Planning & Urban Development Department

March 24, 2015

CBL: 010 E001001
Located at: 184 ANDERSON ST (200).

This letter is written to memorialize recent conversation(s) with Eli Cayer and recent site visits regarding your building/ property located at 184 Anderson St. (the "Building").

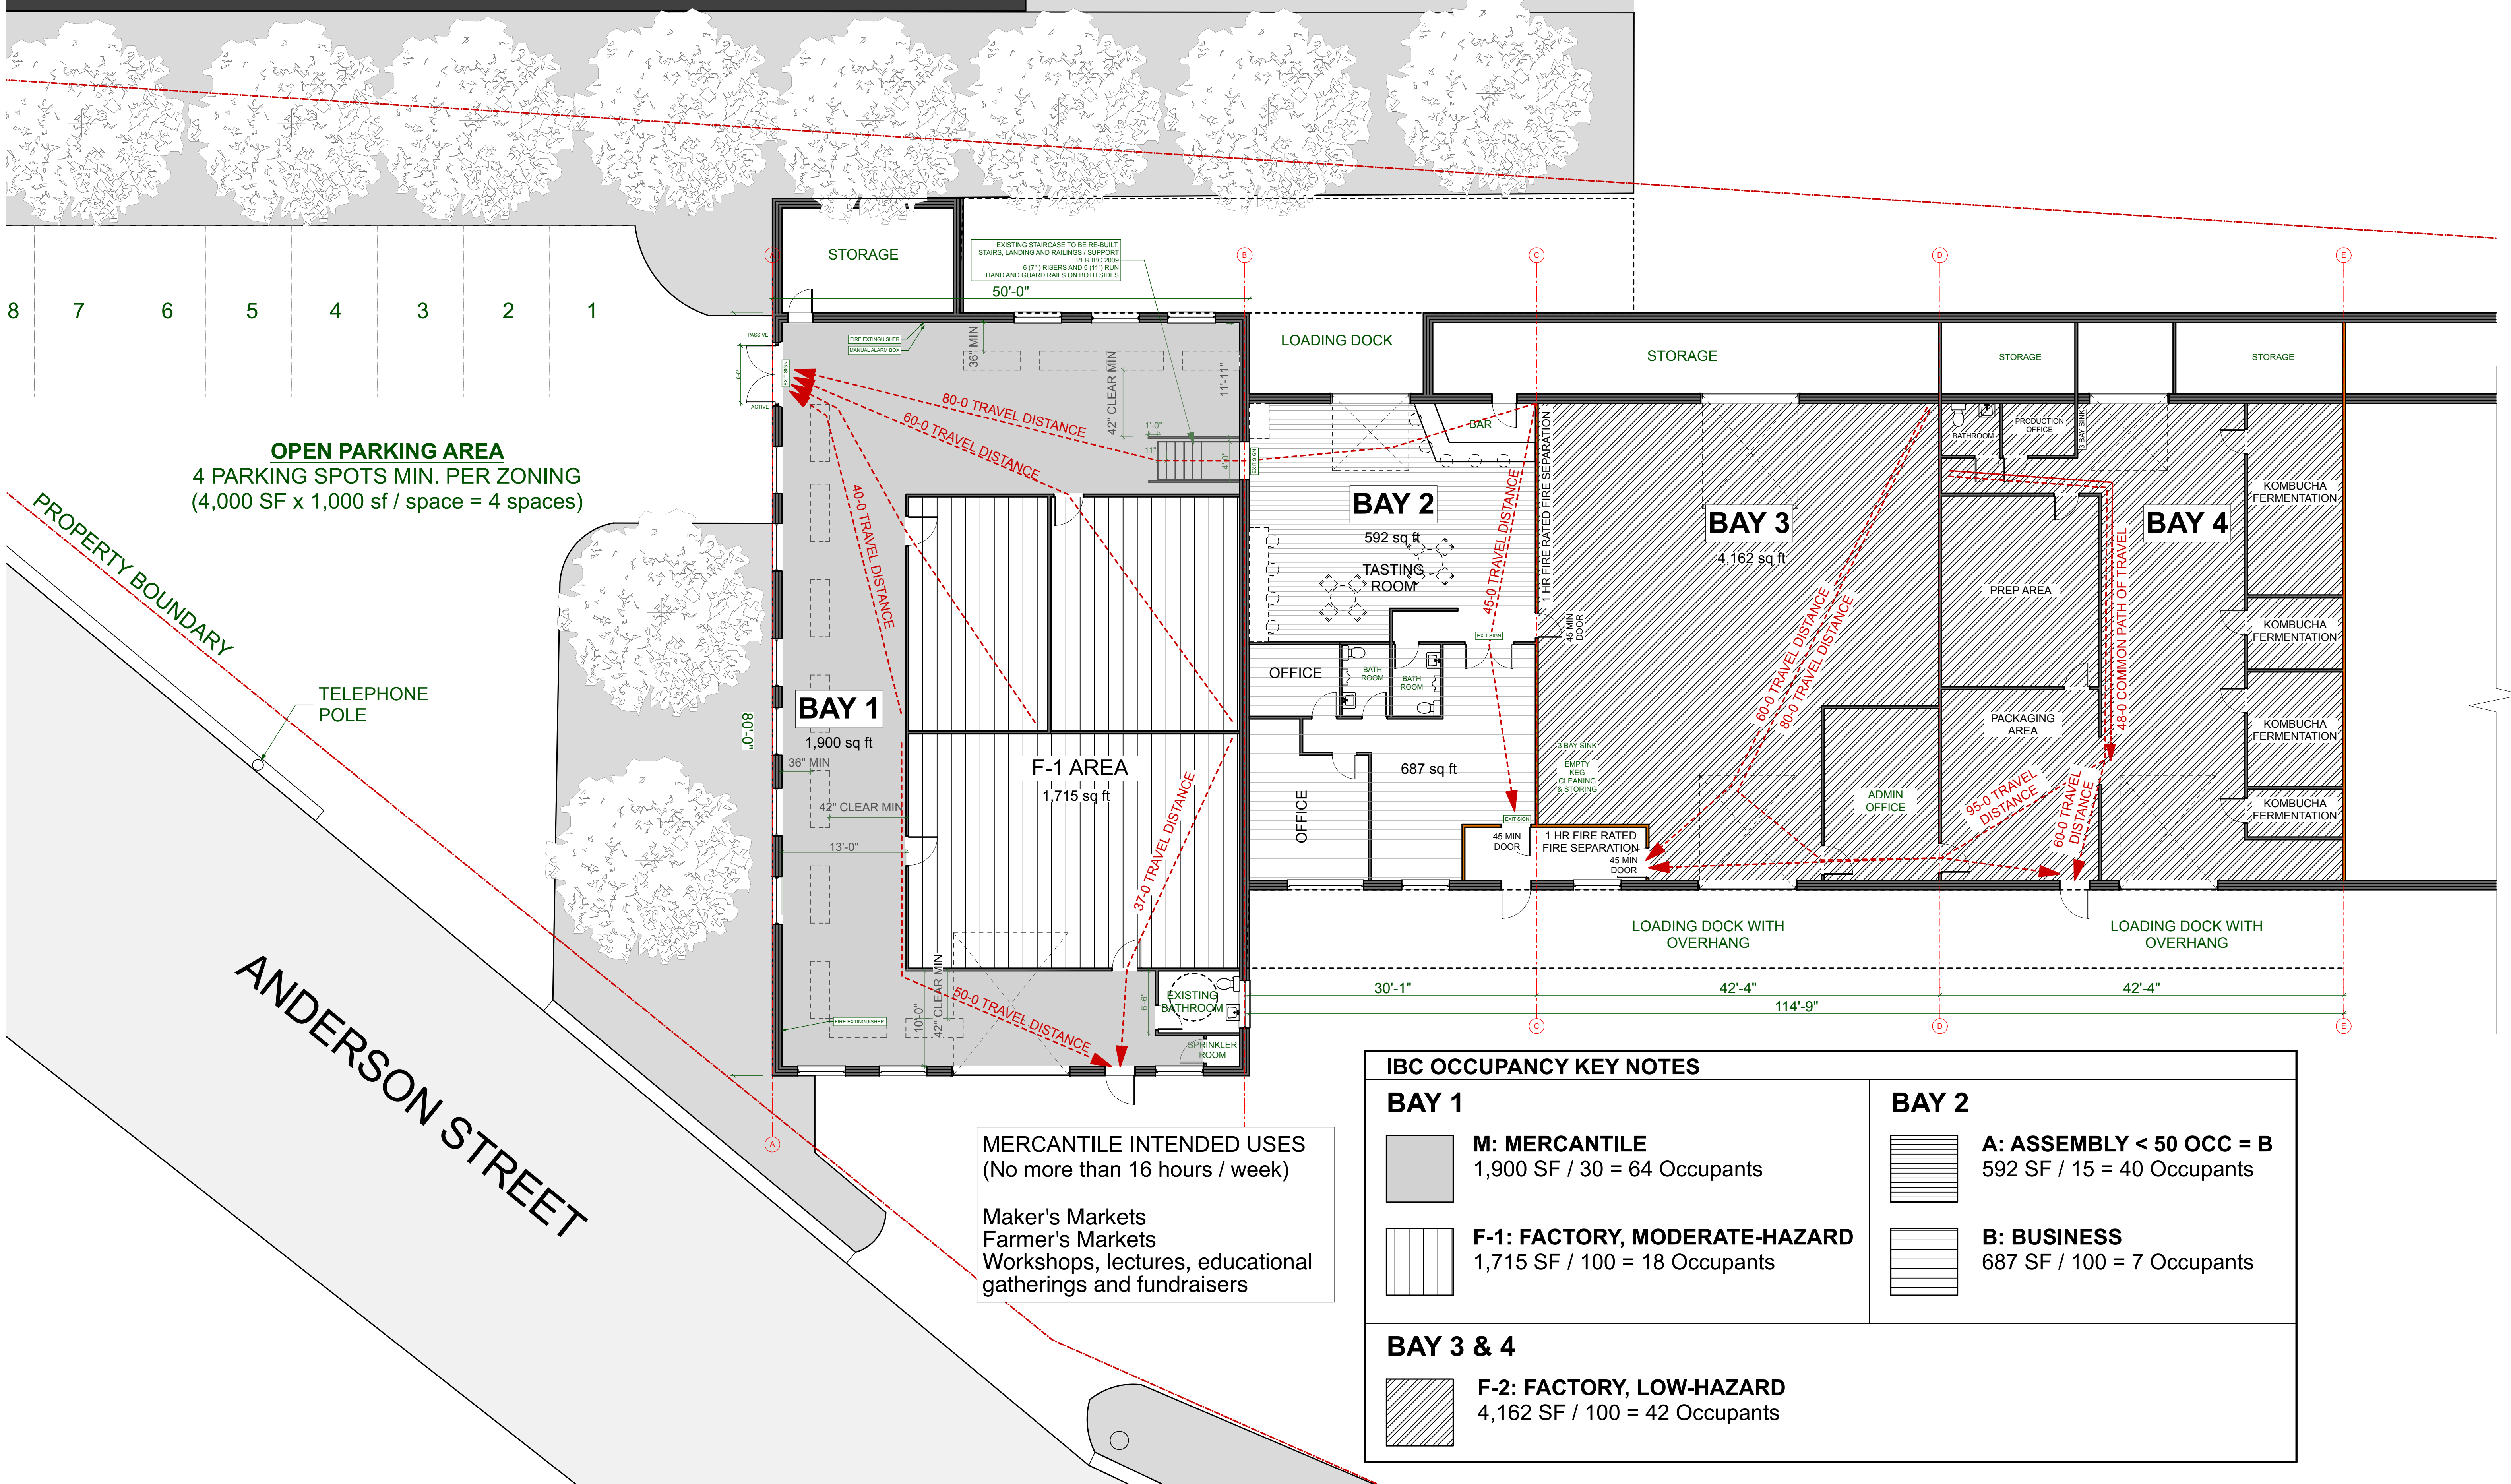
- 1) The stairs in "Bay 1" and the "Loading Dock" must meet the minimum IBC, 2009 (MUBEC) code requirements (i.e. rise, run, guards, handrails & risers), and
- 2) The fire rated assembly between "Bay 3 (F-2) and Bay 2 (B)" and the shared Exit fails to meet minimum continuity, penetration(s) and openings (fire doors) code requirements, see Permit #201400580.
